# CITY OF ALBUQUERQUE

December 1, 2022

**RE: MDS - Montage Subdivision Unit 7 on Bobby Foster  
Grading and Drainage Submittal for Preliminary Plat and Grading Permit  
Grading Plan Engineer's Stamp Date: 7/13/22  
Drainage Report Engineer's Stamp Date: missing  
Hydrology File: R16D100A**

Pldt: 1/19/2023 5:20:30 PM, By: Trujillo, Corie
BASINS 7 - Montage Unit 7 - Mesa del Sol
Last Saved: 1/19/2023 5:18:42 PM, crujillo

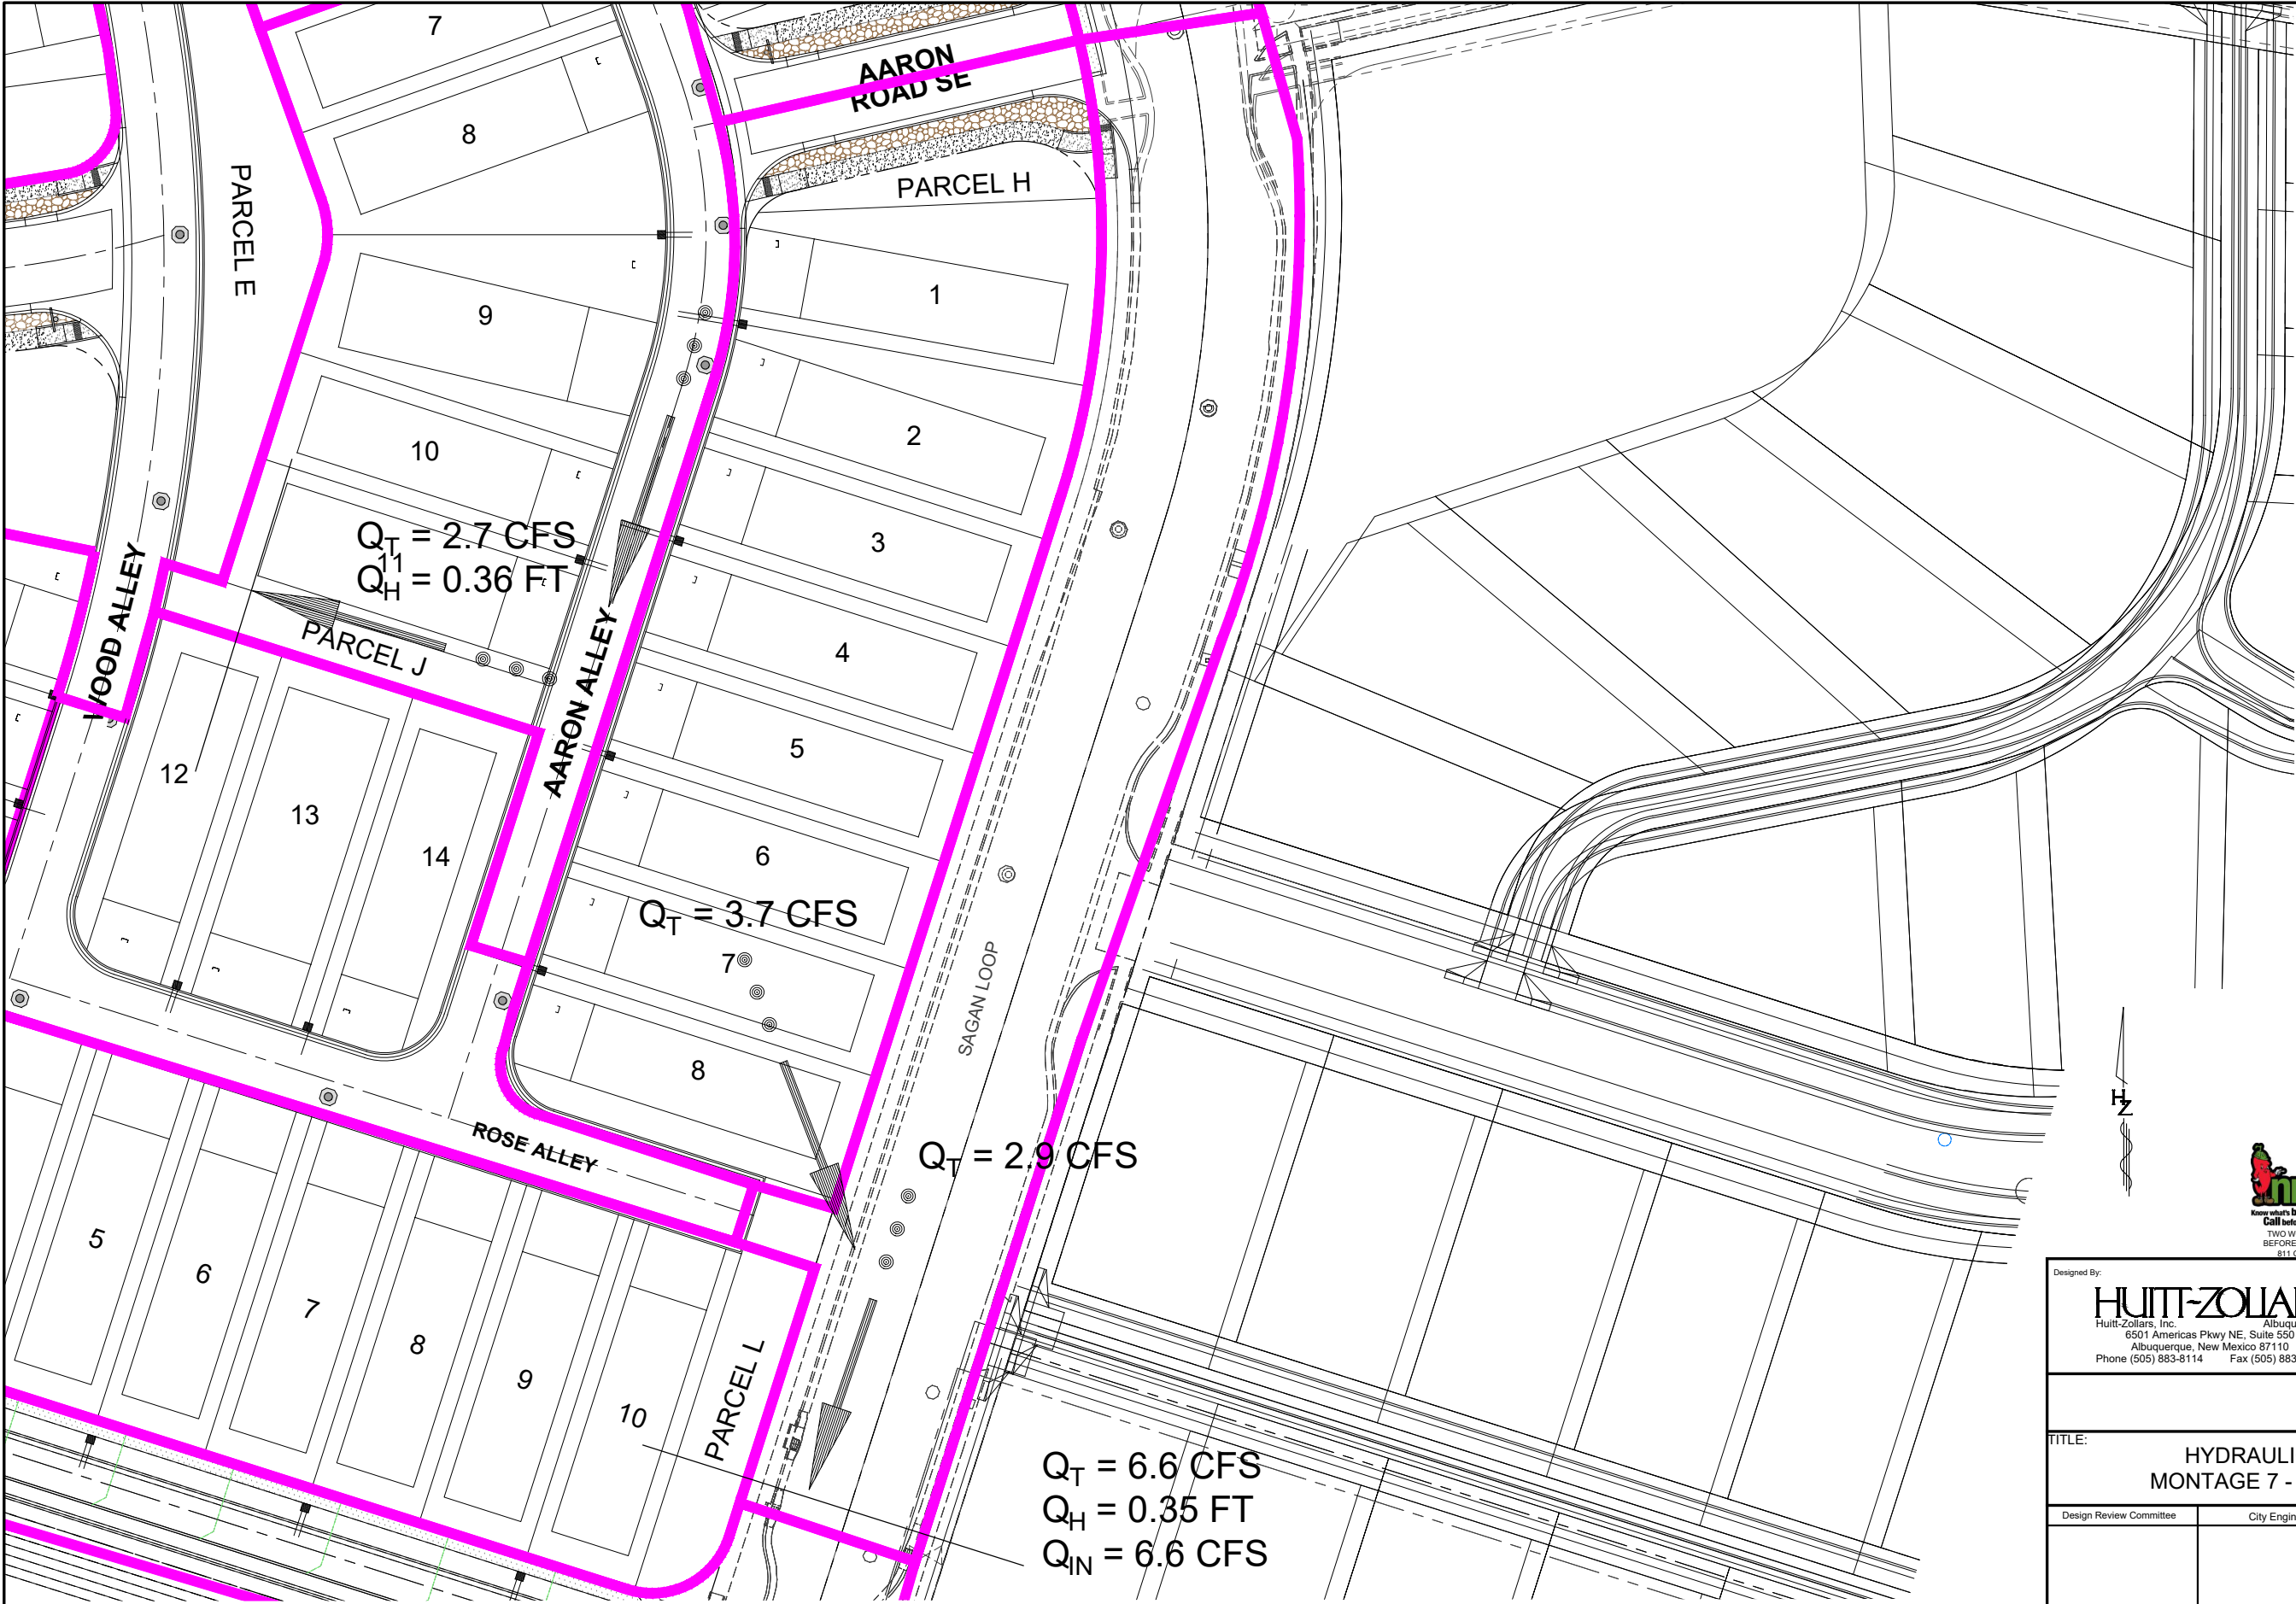
Provide surface drainage analysis demonstrating that the 100-year HGL remains at/below top of curb, and the 100-year EGL remains within the ROW for the onsite streets and alleys and the adjacent streets that receive drainage from this site per DPM 6-9(A).

7. StormCAD is used in the Montage Unit 7 Report but insufficient information has been provided to show that it meets DPM requirements. Hydraulic calculations must be performed along the Energy Grade Line using the Bernoulli Equation, per the DPM. The calculations presented in HEC-22, 3rd Edition agree with the DPM but the earlier editions (1st and 2nd) do not use Bernoulli's correctly. The City of Albuquerque-Hydrology Section accepts the manhole loss methodology presented in HEC-22, 3rd Edition, section 7.1.6.7 and rejects the two methods prescribed in HEC-22, 1st Edition and 2nd Edition. StormCAD v8i SELECTseries5 (build 08.11.05.58) and later, by Bentley, is acceptable provided that the calculations are performed using HEC-22, 3rd Edition and the user selects the "Energy Grade" option for losses. Provide detailed input and output files to demonstrate compliance with the DPM.  
The flow rates in the pipes must be supported by inlet interception rates which are based on 100-year flow depths and velocities in the streets per DPM procedures for inlets on grade. Hydraulic grade line calculations and pipe profiles will be required prior to drainage report approval for (WO).

Grading Plan Submittal

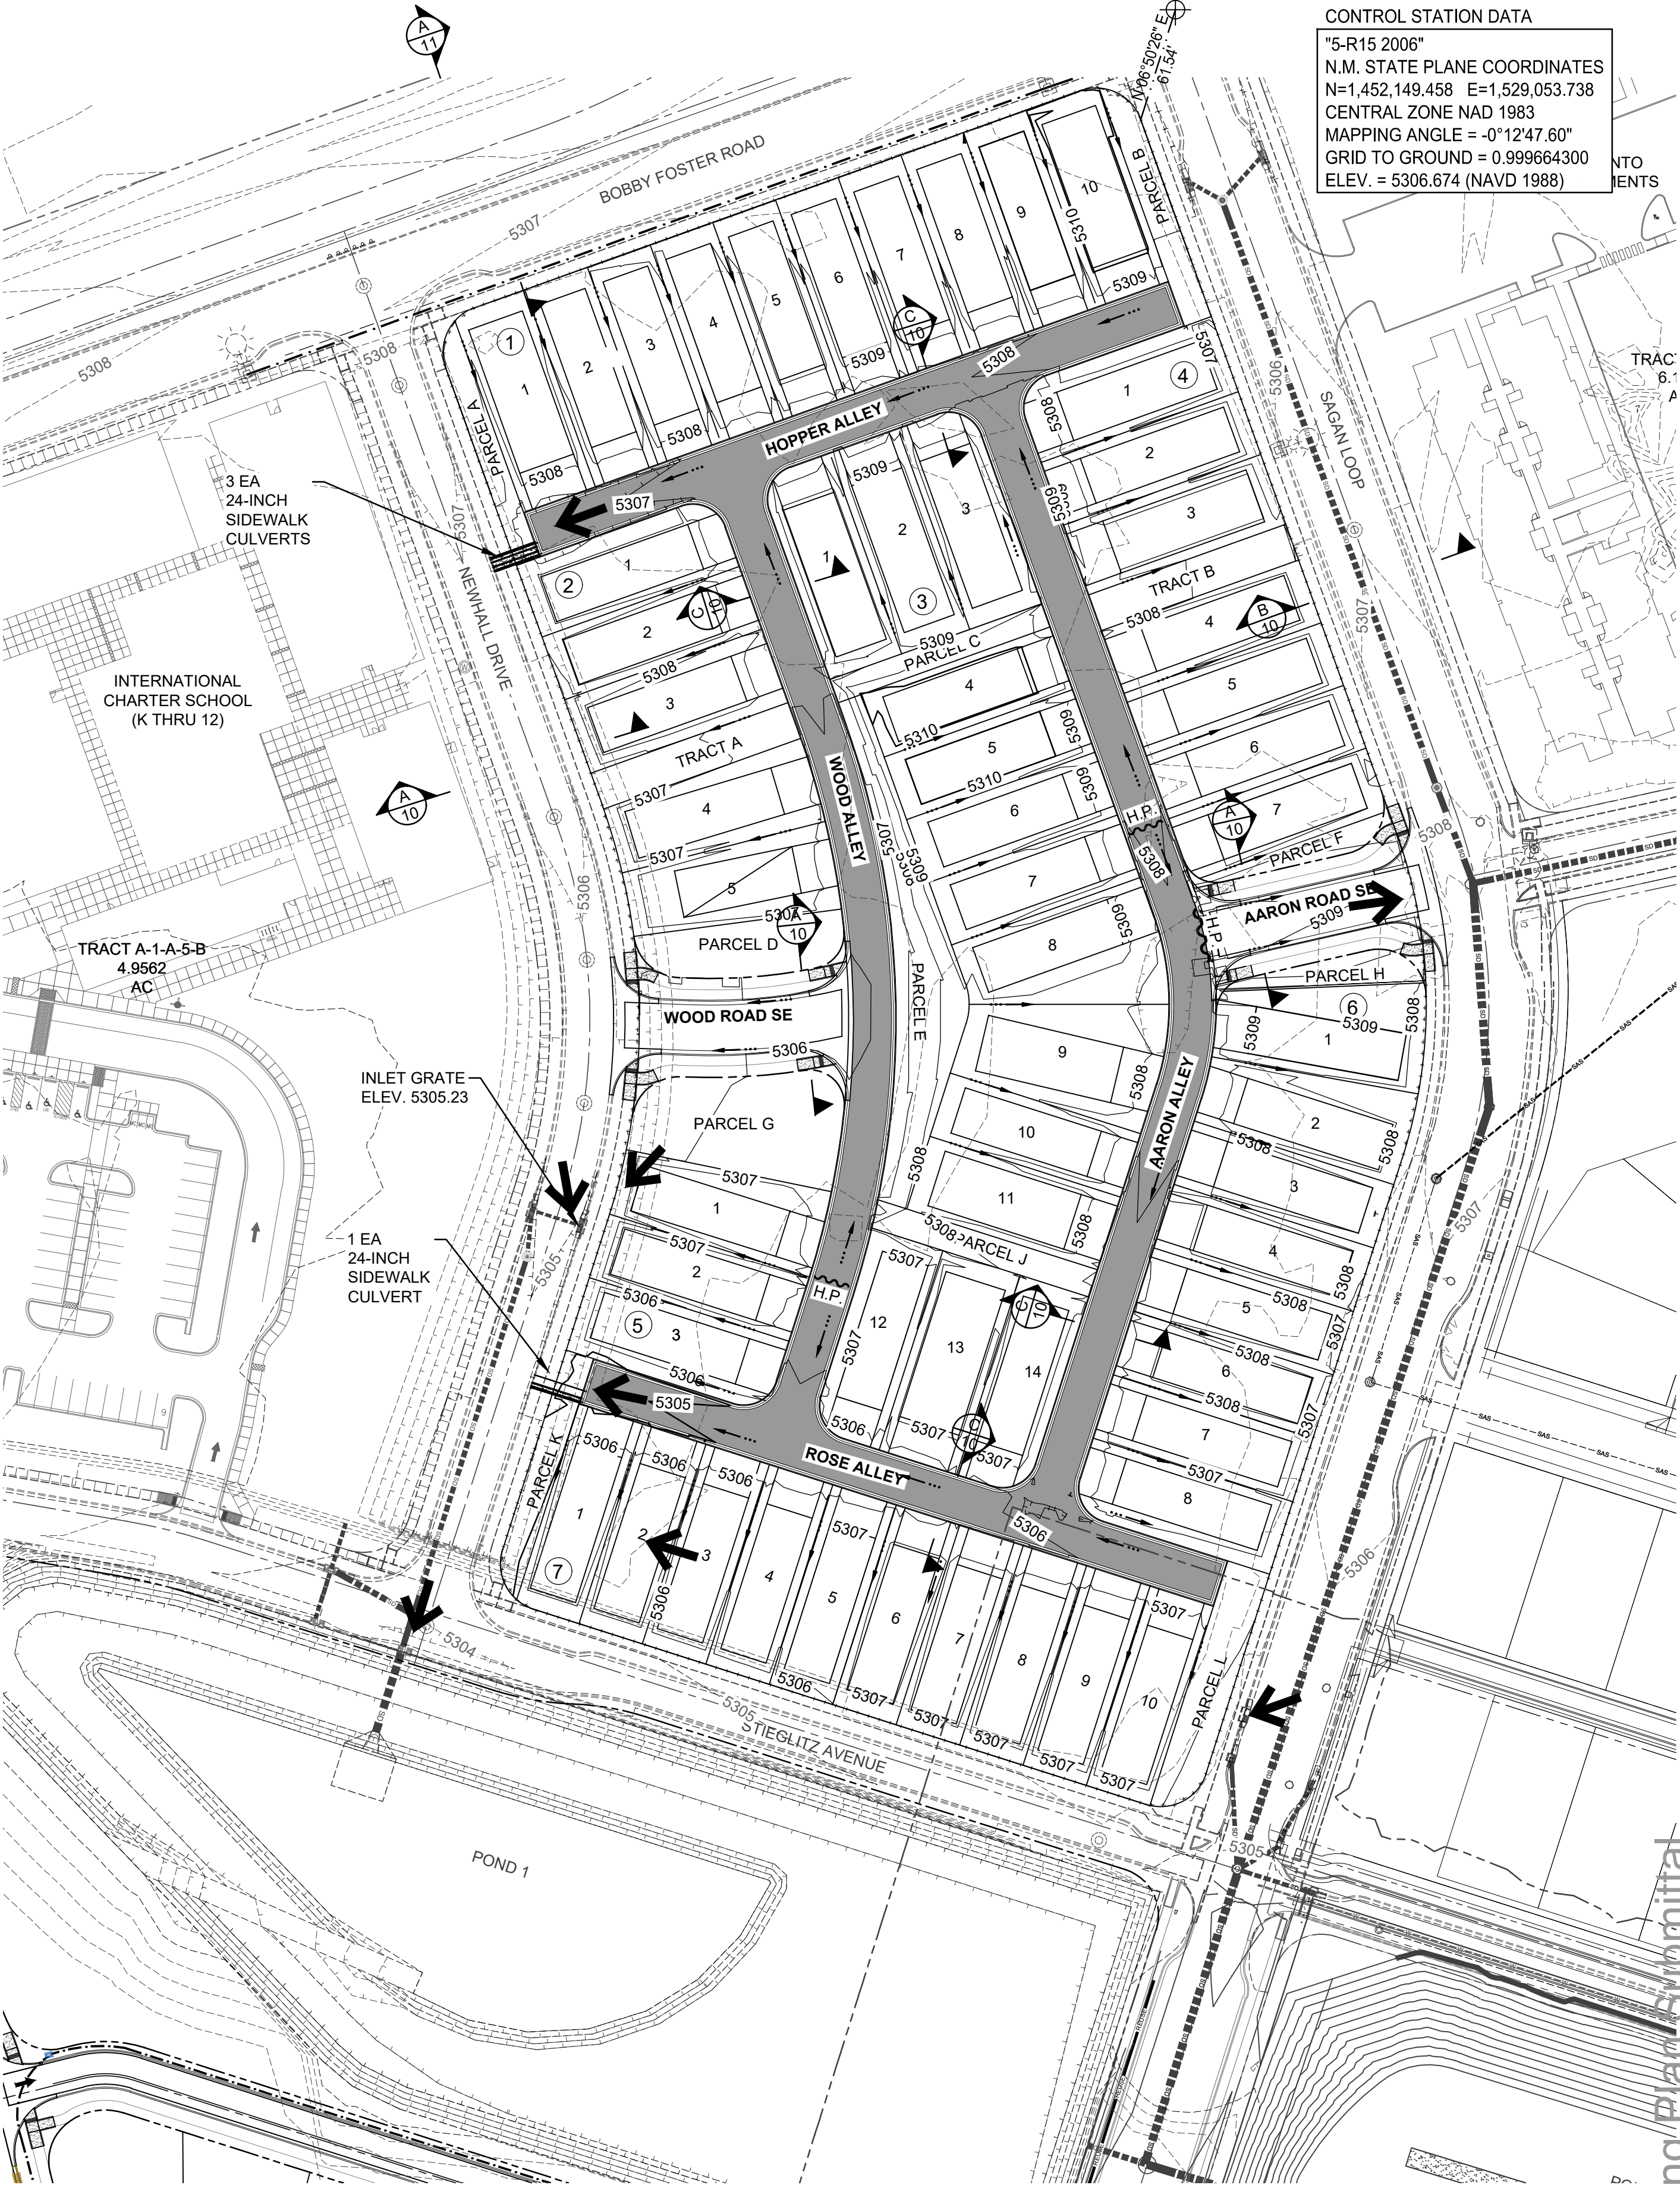
1. The Grading Plan that was missing from the first submittal was provided with this second submittal, but it is still missing typical sections of streets, alleys, retaining walls, and other details on the Grading Plan Checklist, DPM 6-14(C). The new plan raises these additional concerns.

- a. Please provide the Benchmark information (location, description and elevation) for the survey contour information provided.
  - b. Please provide the FIRM Map number in a flood plain note with effective date.

- c. Please provide a legal Description of the property.
  - d. Show both existing and proposed storm pipes and inlets with sizes.
  - e. Show sidewalk culverts in Parcels A & K, box culvert in Parcel G, and drainage channel in Parcel J labeling the number, size, and type of each. Add details of connection to streets at both ends of each.

- f. Provide typical sections of drainage structures thru Parcels A, G, J, and K with material specifications, lot lines, and dimensions.
  - g. Add valley gutters through the alley intersections. Provide valley gutters at each of the four alley intersections in accordance with the Intersection standard DWG 2401 and Concrete Valley Gutter standard DWG 2420.

- h. The highest point at entrance 2 is at the valley gutter for Alley D; so, Alley D will drain out the entrance to Sagan Loop contrary to the drainage Basin Map. Instead provide a water block farther to the east in entrance 2 to and adjust the Basin Map accordingly.

- i. Add a typical lot grading detail with typical section through the side yards at the front corner of the houses. The plan should clearly indicate which portions of each lot drains to the alley and to the street.

- j. Add typical sections from the house pads to the existing adjacent street showing the maximum grade change between pad and street. Show how that grade change is to be accomplished on the private property, while maintaining the required typical sections within the public right of way per COA DWG 2414. Correct the grades shown on the sidewalk around the perimeter to agree with the projected 2% grade shown on the detail.

- k. Identify Landscape Buffer Swales per COA DWG 2414 along all of the adjacent public streets with a hatch pattern in the legend and in the plan view.

- l. Identify all right-of-ways and drainage easements.
  - m. The layout and sections of the streets, alleys, and sidewalks as shown on the Grading Plan must match the Traffic Circulation Layout, but a traffic plan hasn't been submitted yet. So, a condition of approval will be that the sections match and the G&D Plan will have to be revised if they don't.
